1 December 2025

PLANNING OBJECTION TO SSD-35609161-MOD-1 (FOR REDUCING BUILDING HEIGHT, ADDING 47 DWELLINGS, ADJUSTING LAYOUTS, SETBACKS, FAÇADES, AND AMENITIES, AND RELOCATING SERVICES—ALL WITHIN THE APPROVED ENVELOPE)

PROPERTY: 1 - 12 HASSALL STREET, PARRAMATTA, 2150 (LOTS 156 DP 1240854)

Title
B-GENERAL ARRANGEMENT PLANS
BASEMENT LEVEL 1 FLOOR PLAN

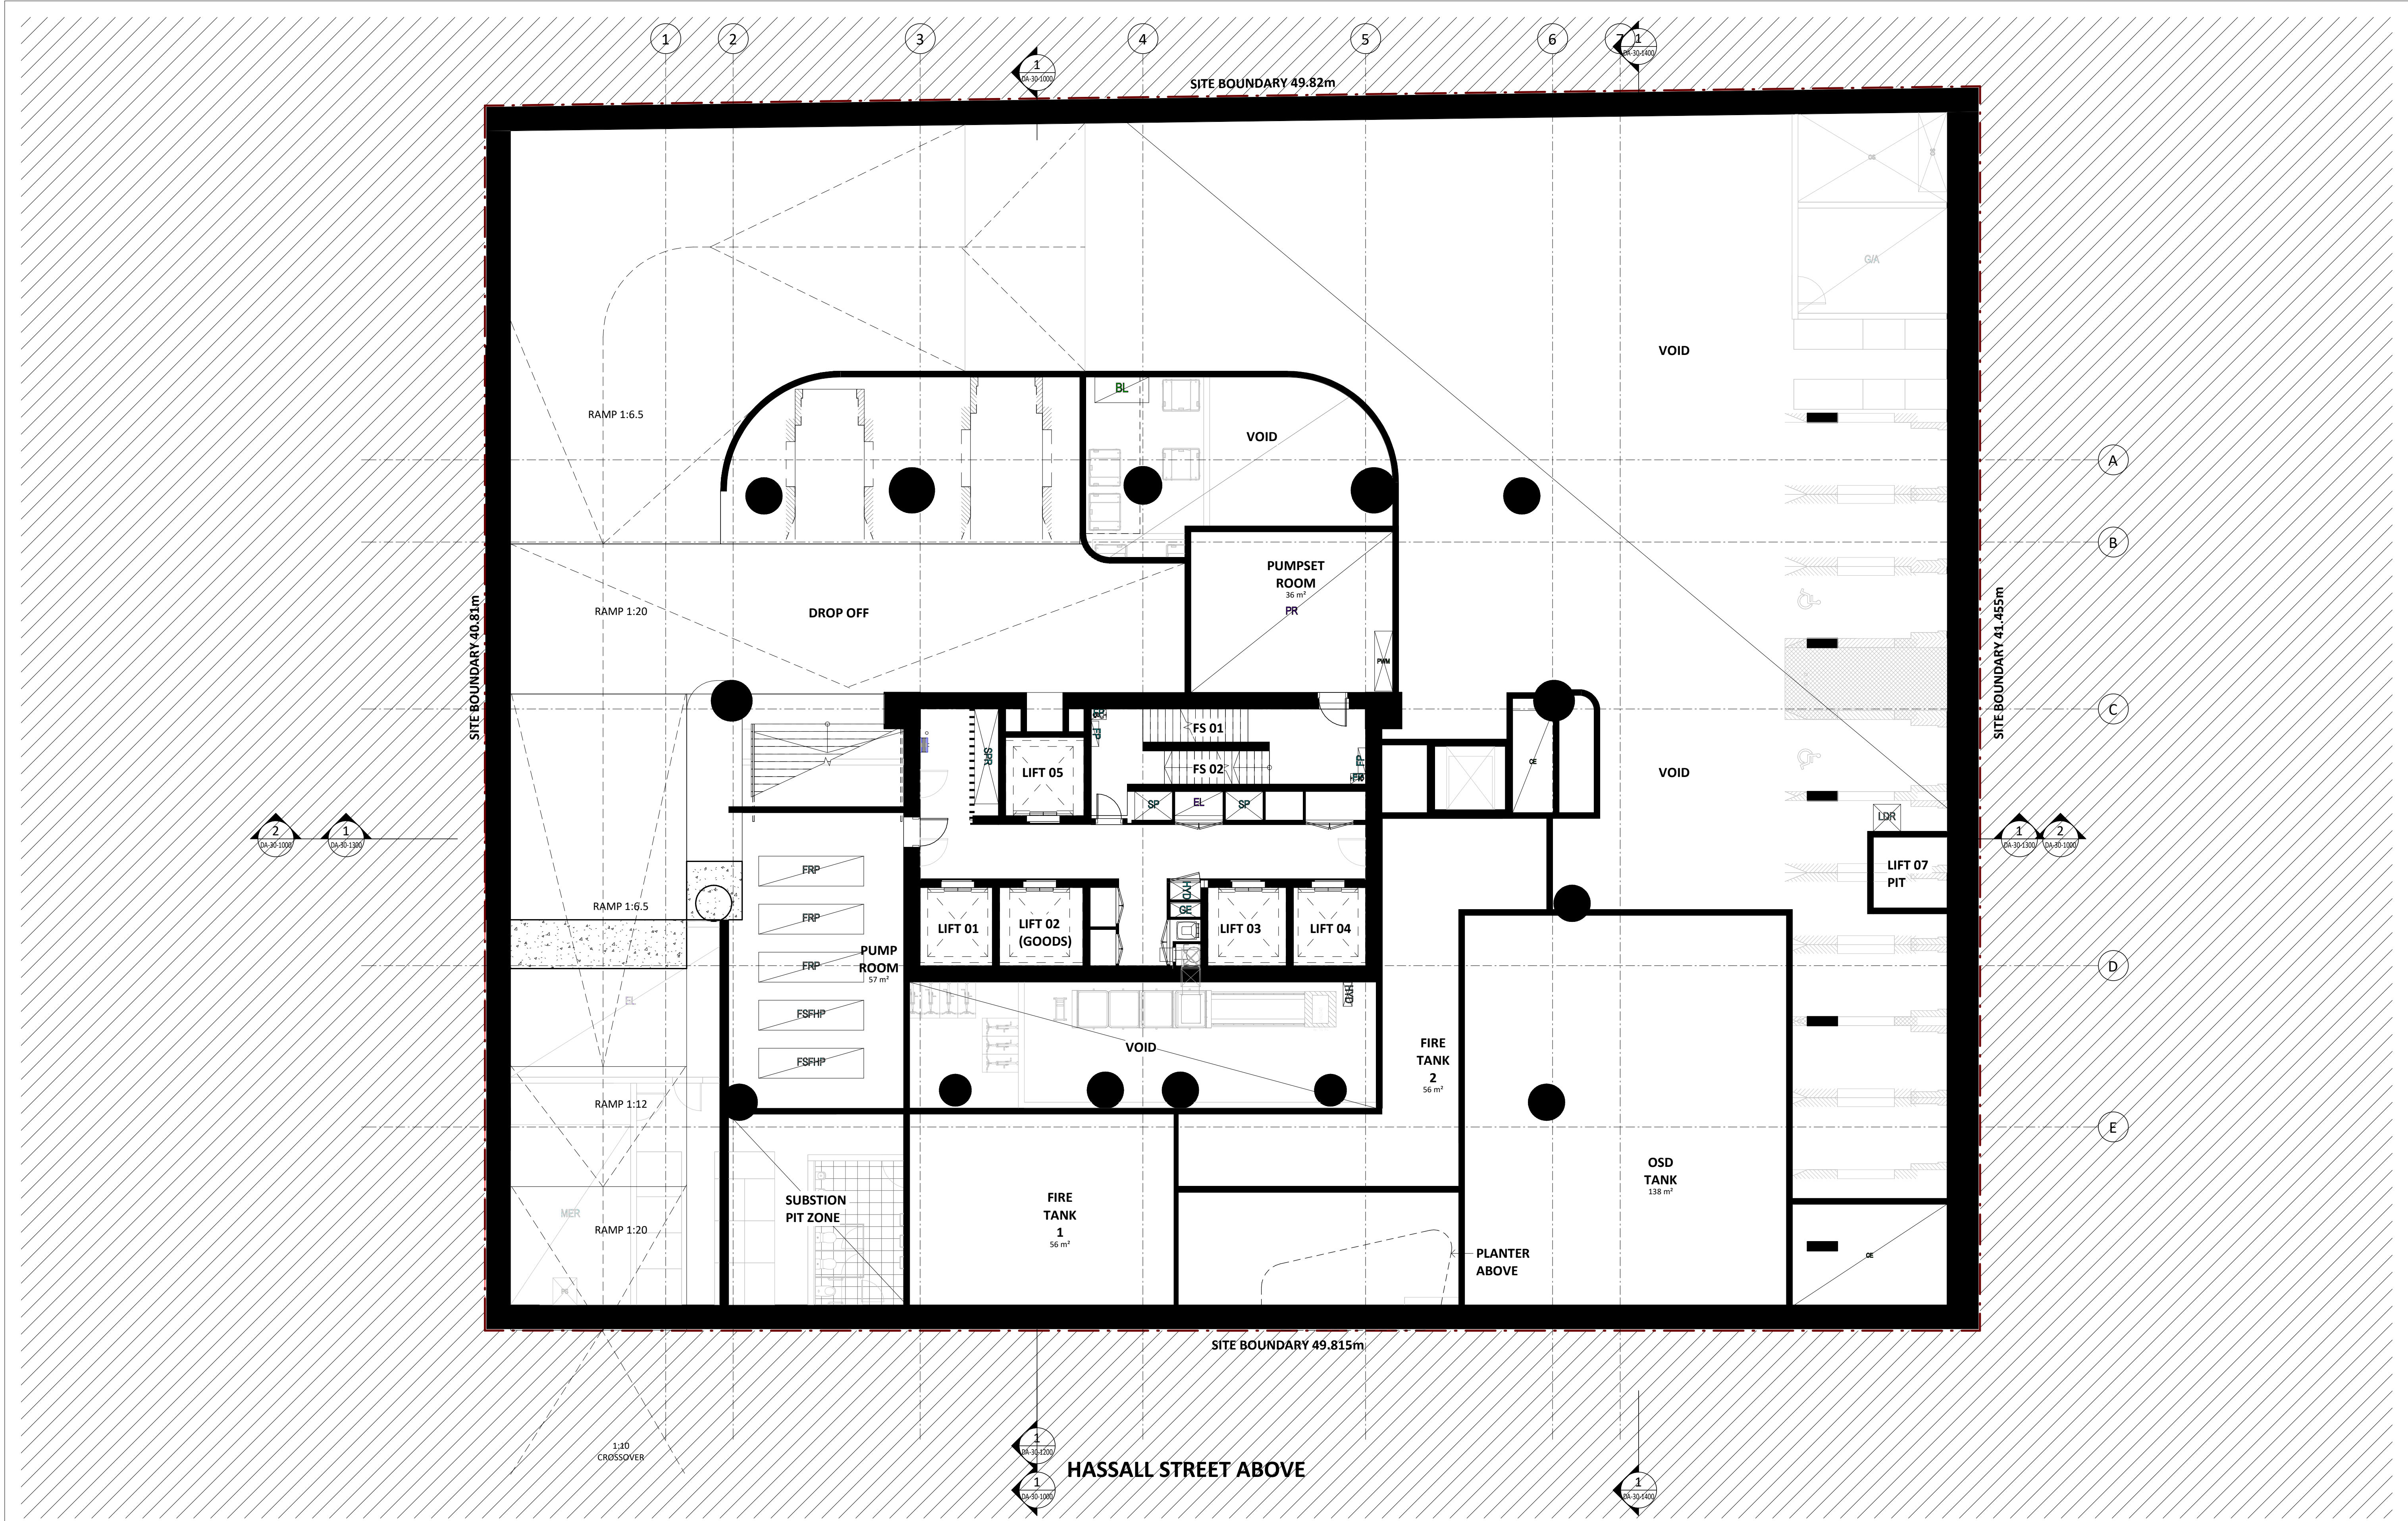
- **Substantial parking reduction creating overflow impacts** – While the proposal increases dwelling numbers by 47 units (12%), it simultaneously reduces car parking by 95 spaces (54%), from 175 spaces in the approved scheme to only 80 spaces. This results in a provision rate of only 0.18 spaces per dwelling compared to 0.45 in the approved scheme, a 60% reduction per unit. The Addendum Traffic Impact Assessment Report acknowledges that it does not comply with the Transport for NSW guidelines. In accordance with the Transport for NSW guidelines, the development would require 198 spaces based on the apartment mix, meaning the proposal creates a shortfall of 118 car parking spaces (60% of requirement). It is worthwhile noting that the SSDA residential component for car parking was assessed under Clause 7.15 of PLEP2011. This modification application makes no assessment against this clause, and this raises concern surrounding the carparking shortfall and reduction.

- Reduction from 175 to 80 car parking spaces (reduction of 95 spaces, 54% decrease)
- Increase from 391 to 438 apartments (+47 dwellings, 12% increase)
- Net result: 438 apartments served by 80 spaces (0.18 spaces per apartment)

Title
B-GENERAL ARRANGEMENT PLANS
LEVEL 00 GROUND FLOOR PLAN

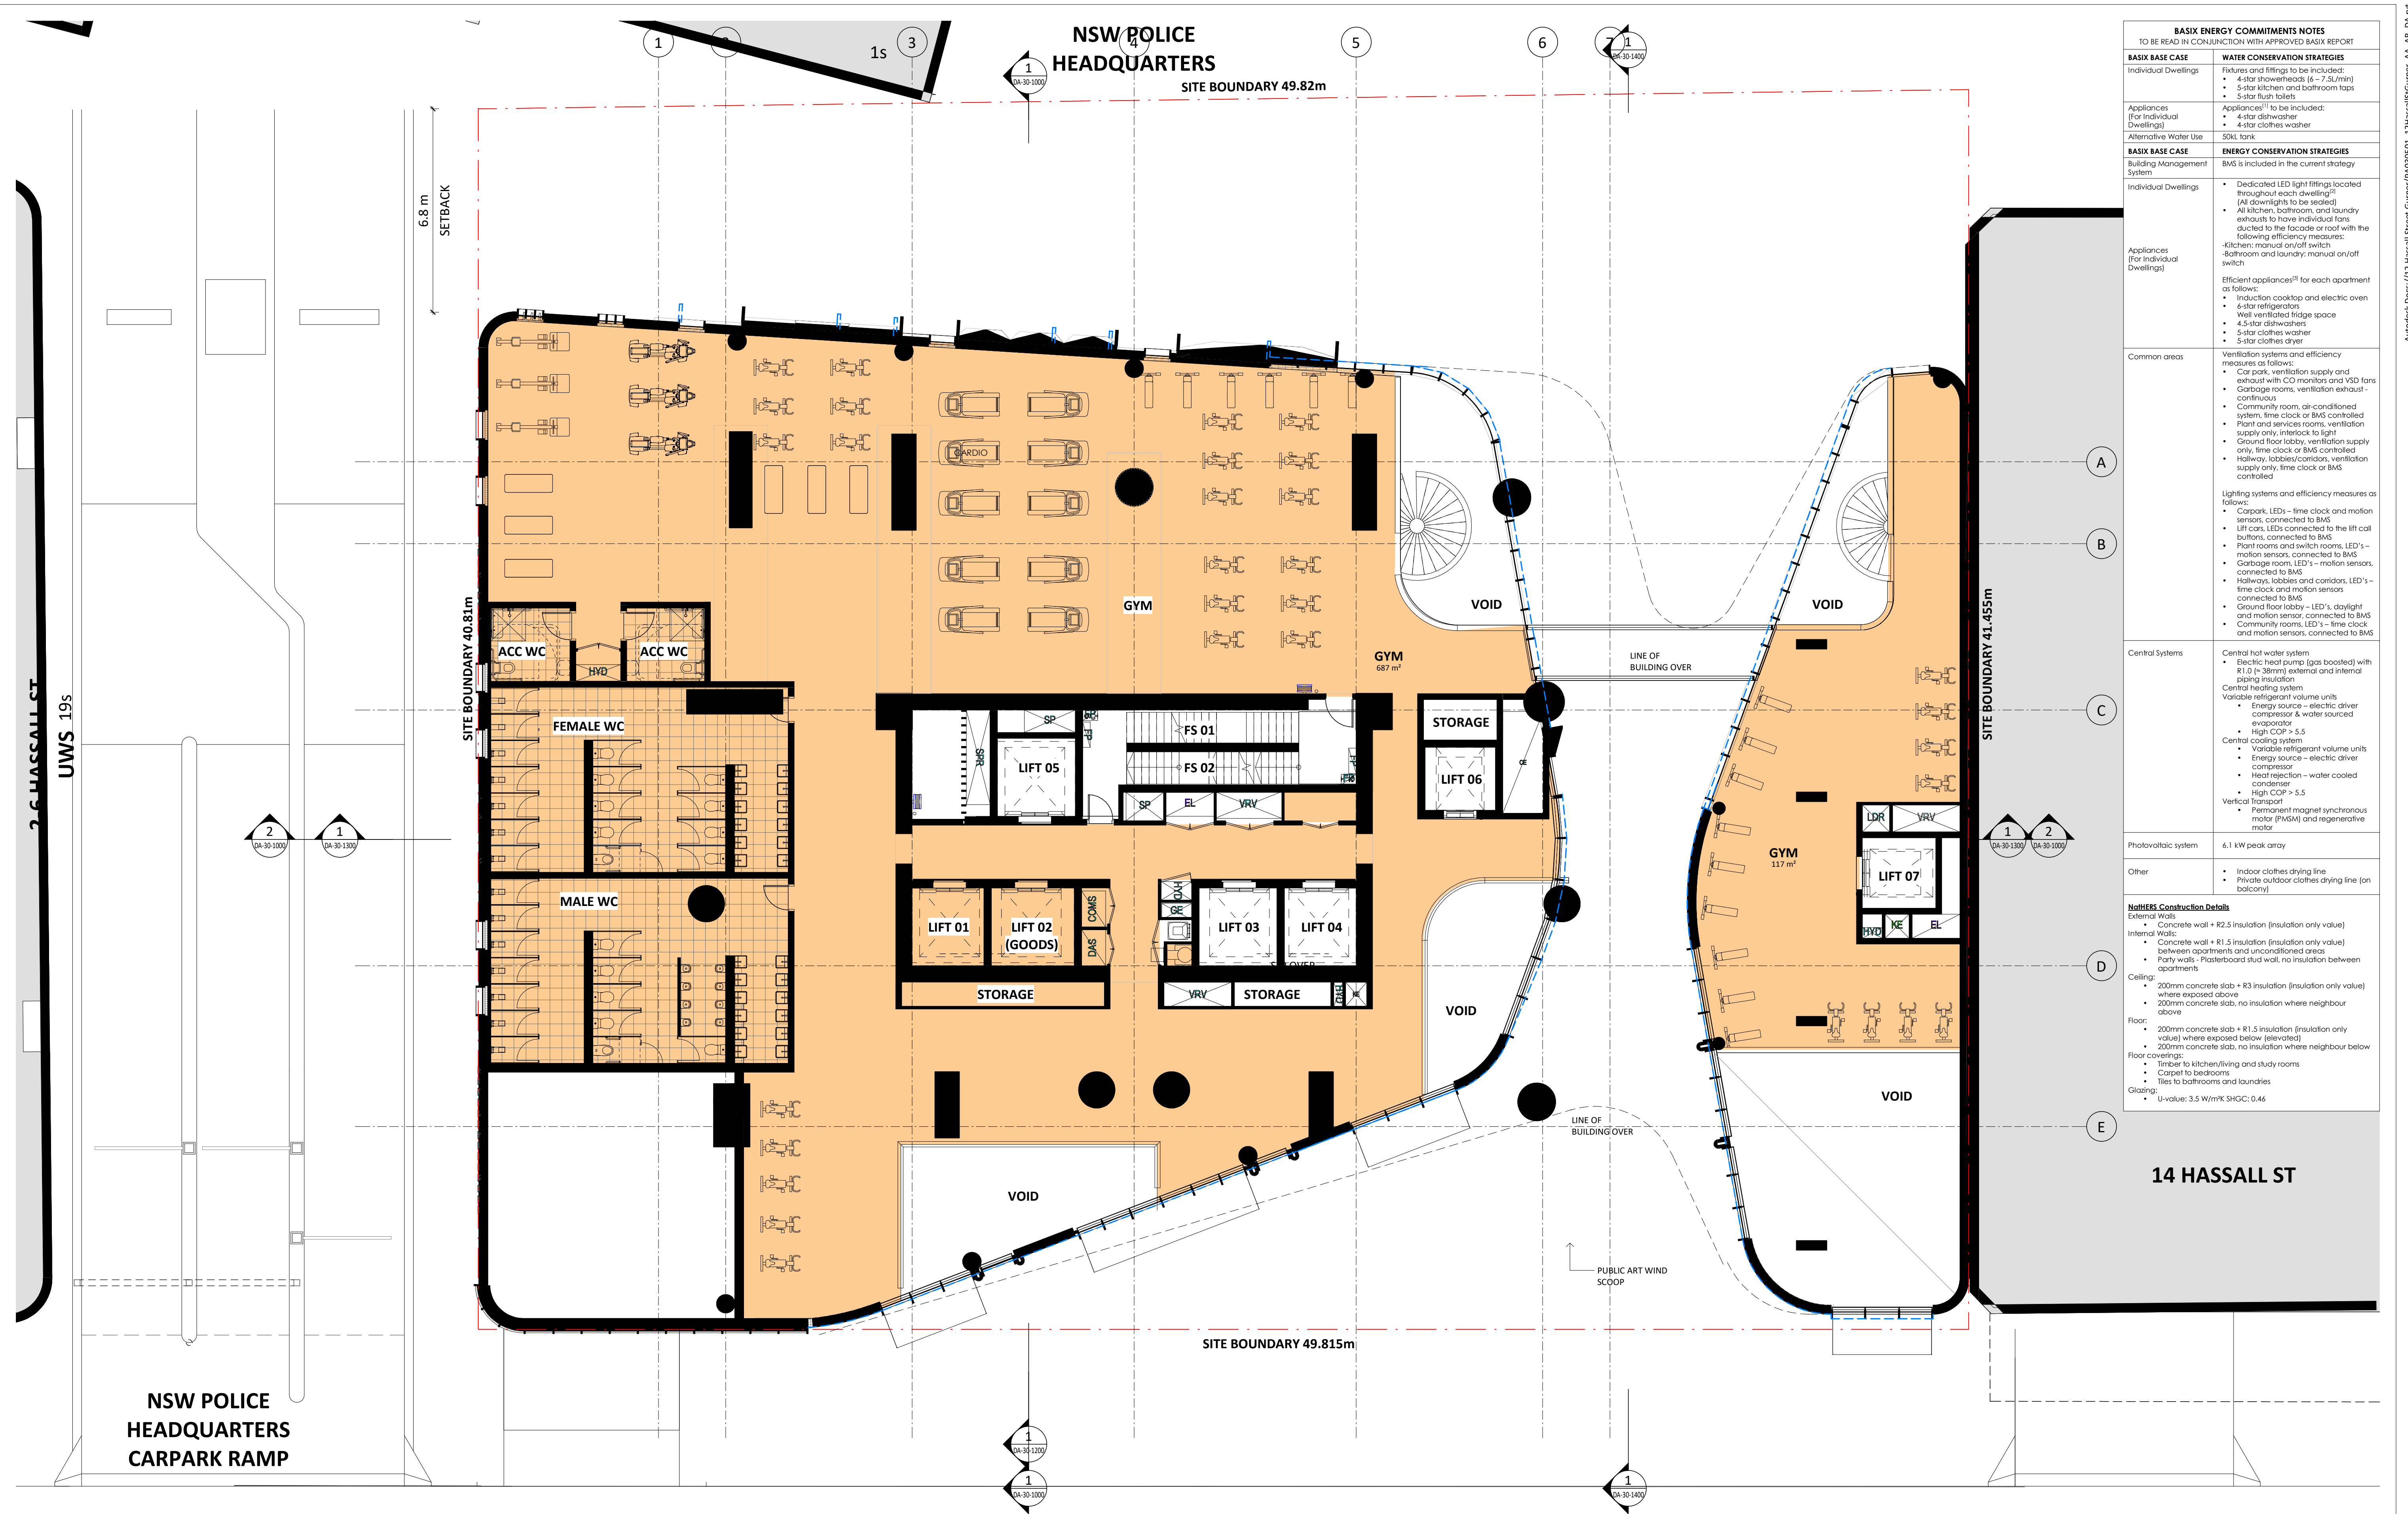
- **Amenity impacts on 1 Charles Street** – The modifications include substantial changes that directly impact the interface with 1 Charles Street, including alterations to façade treatments, the intensification of residential density, and the relocation of the loading dock and waste collection from Basement 01 to Ground Floor Level. The repositioning of these service functions to ground level introduces operational impacts, including vehicle movements, noise, and waste management activities in closer proximity to the shared interface with 1 Charles Street. Additionally, adjustments to the rear stepped landscaping to accommodate the relocated loading dock alter the ground plane relationship between the developments. These changes give rise to amenity impacts that were not fully contemplated or assessed in the original consent and are of particular

- Adding 47 dwellings (12% increase)
- Shifting to 71% studios and 1-bedroom apartments
- Reducing car parking by 95 spaces (54%) while increasing dwellings.
- Relocating loading dock and waste collection facilities to ground level
- Increasing Gross Floor Area (GFA) by 359m² despite losing 7 storeys, a lift, and balconies
- Fundamentally reconfiguring the approved envelope to maximise dwelling yield
